Re: Freddy's at 4315 Wyoming Blvd NE
Erosion and Sediment Control Plan
Engineer's Stamp Date: missing (G19E004G)

Based on the information in your submittal, received on 5/23/24, the above-referenced ESC Plan can't be approved until the following comments are addressed.

James D. Hughes, P.E.
Principal Engineer, Planning Dept.
Development and Review Services

ESC-1

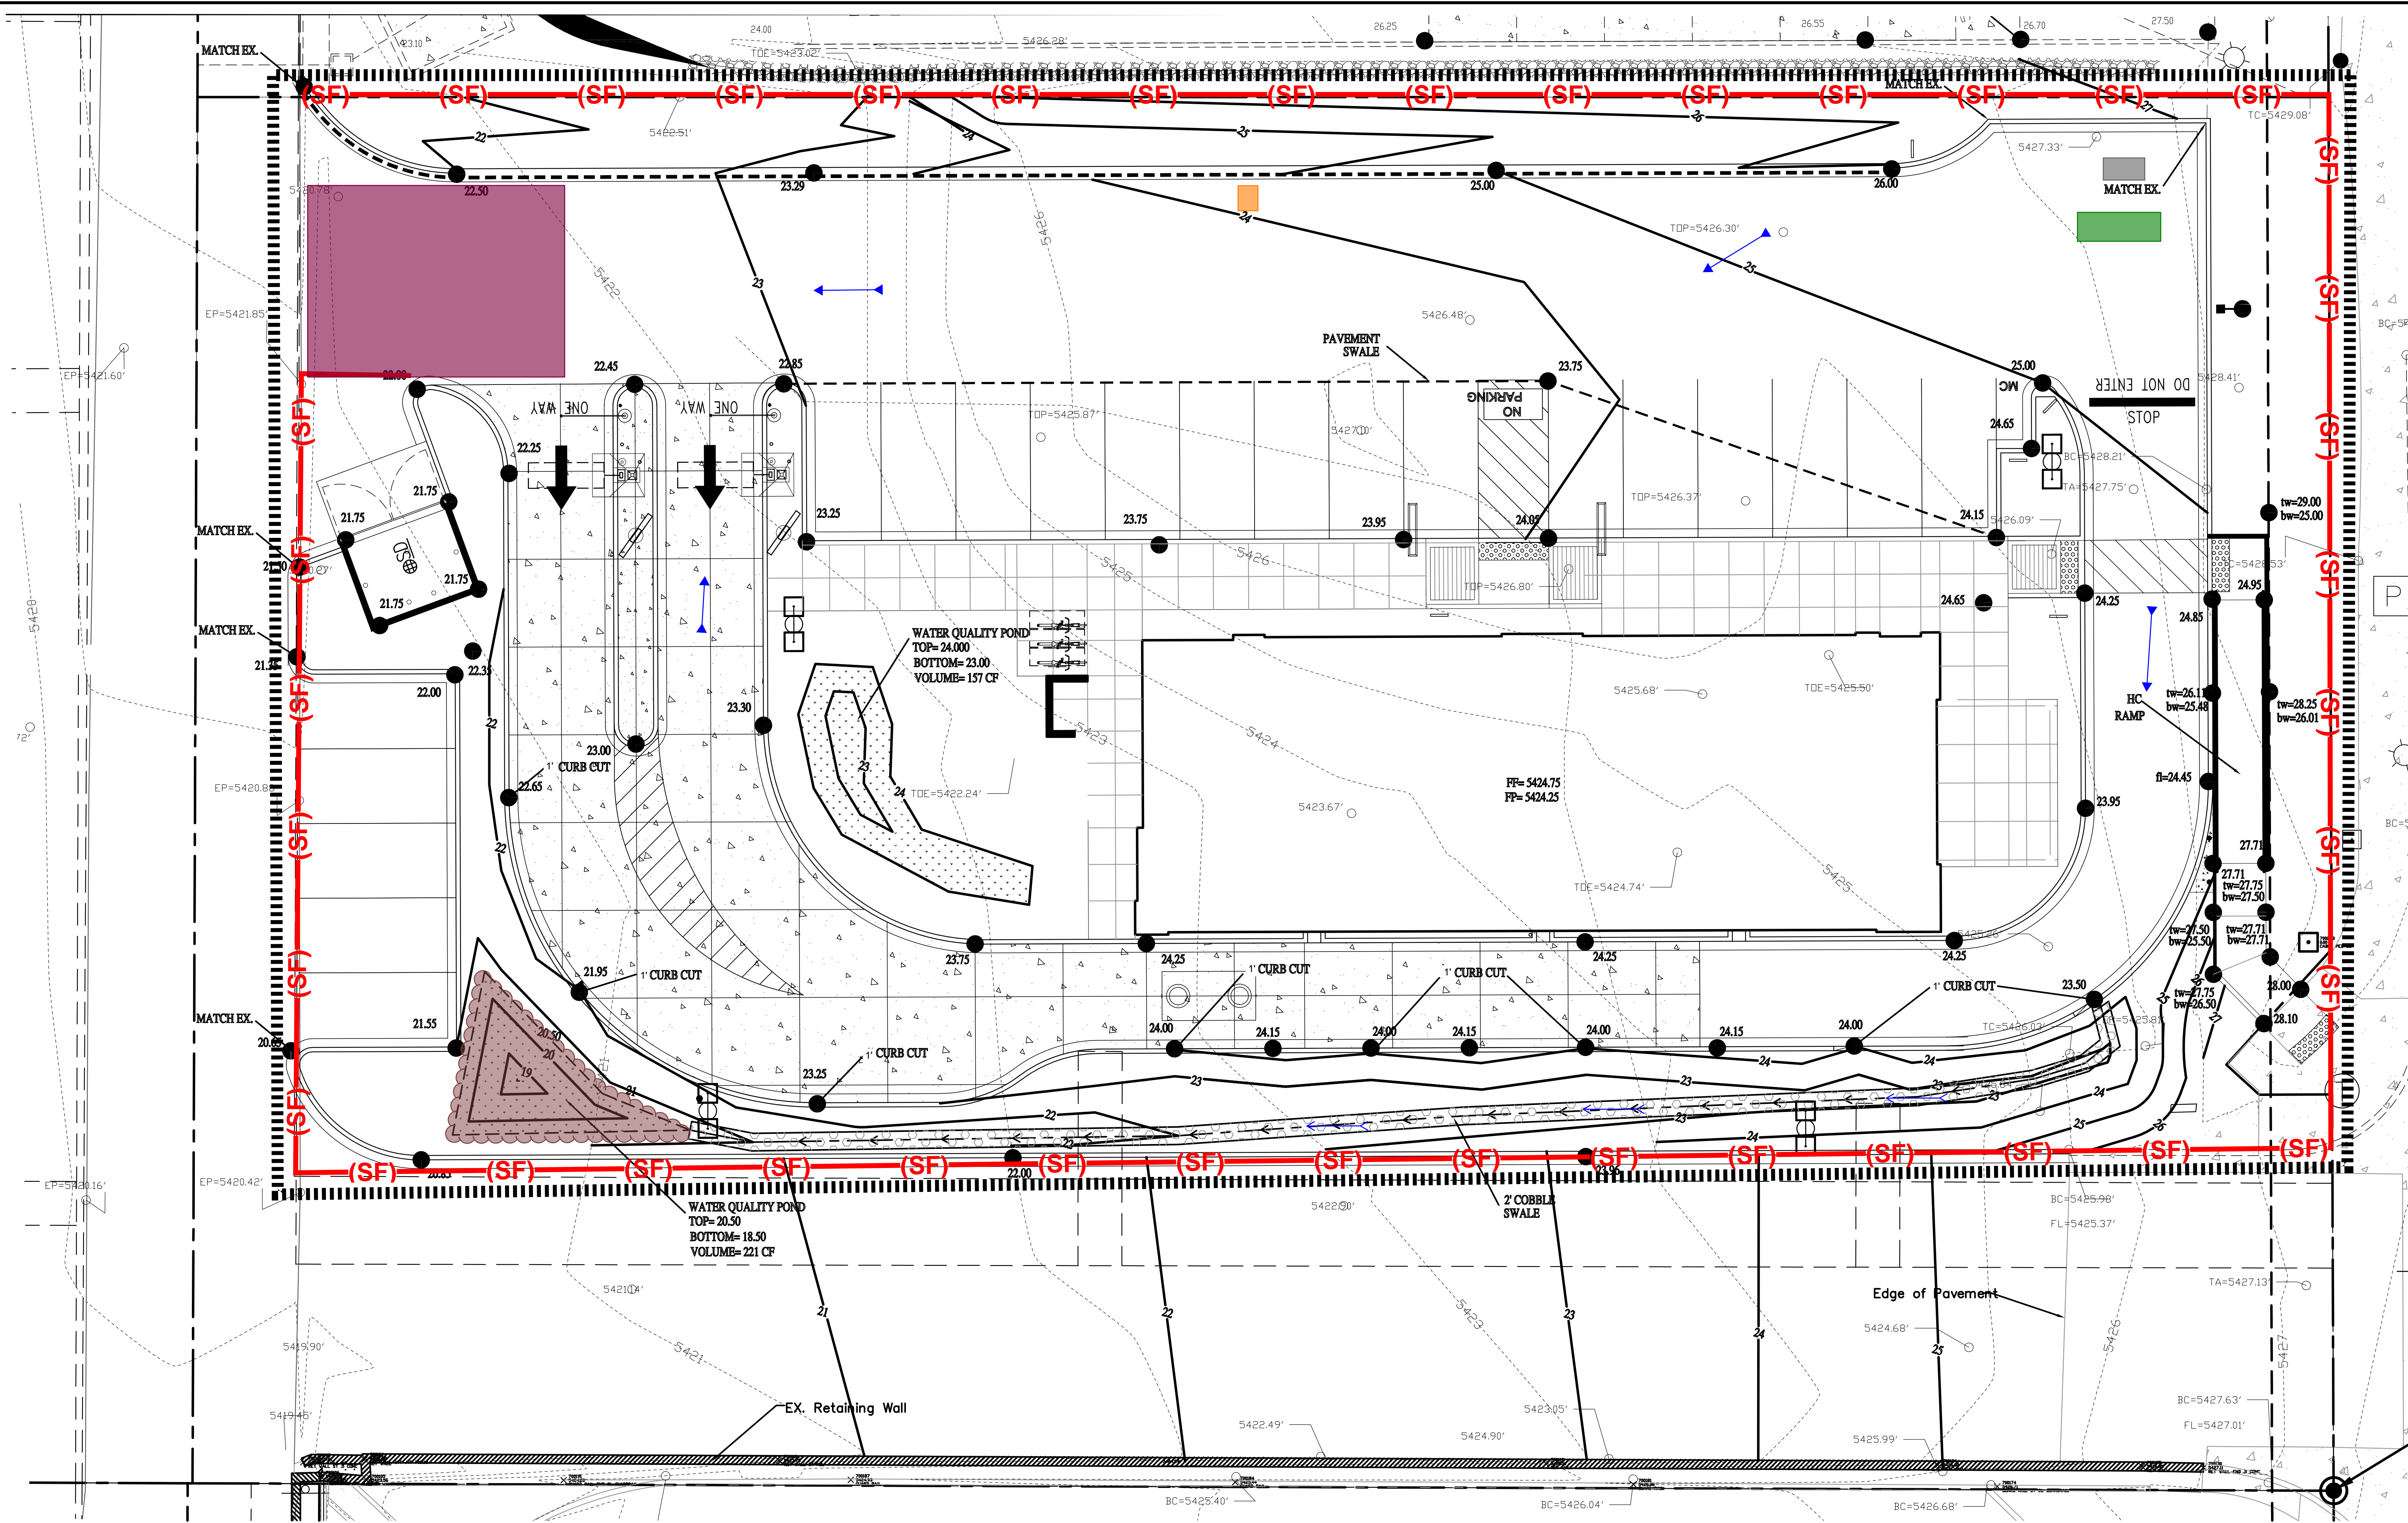
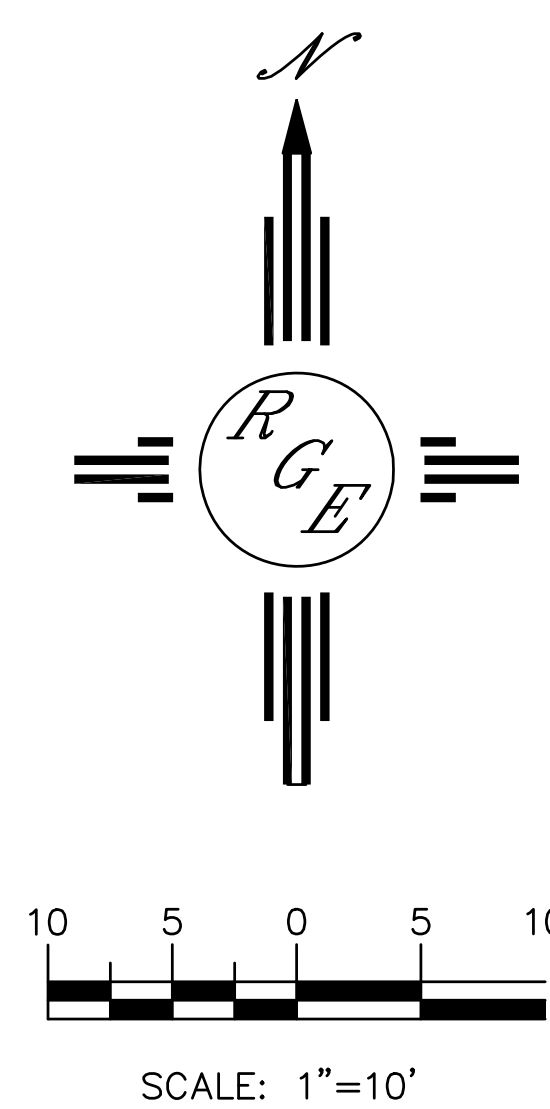
4. A legend showing the limits of disturbance and BMPs is missing and is required by the drafting standards and must be shown on the ESC Plan.
5. The Limits of Land-Disturbing Activities are missing from the ESC Plan. You must accurately identify the location of limits of disturbance on the ESC Plan. Be sure to include any offsite construction support activities in the limits.

6. The Construction Exit (CE) isn't allowed at the handicap ramp on Wyoming Blvd. as currently shown on the ESC Plan. A more likely location is at the end of the existing paved driveway onto Wyoming Blvd. Relocate the CE on the ESC Plan and provide dimensions and construction specifications. Make sure that traffic can't bypass the CE.

9. Construction details and specifications are missing from the ESC Plan for most of the stormwater controls, including but not limited to the construction exit, diversion berms, sediment traps, washout, and waste containers.
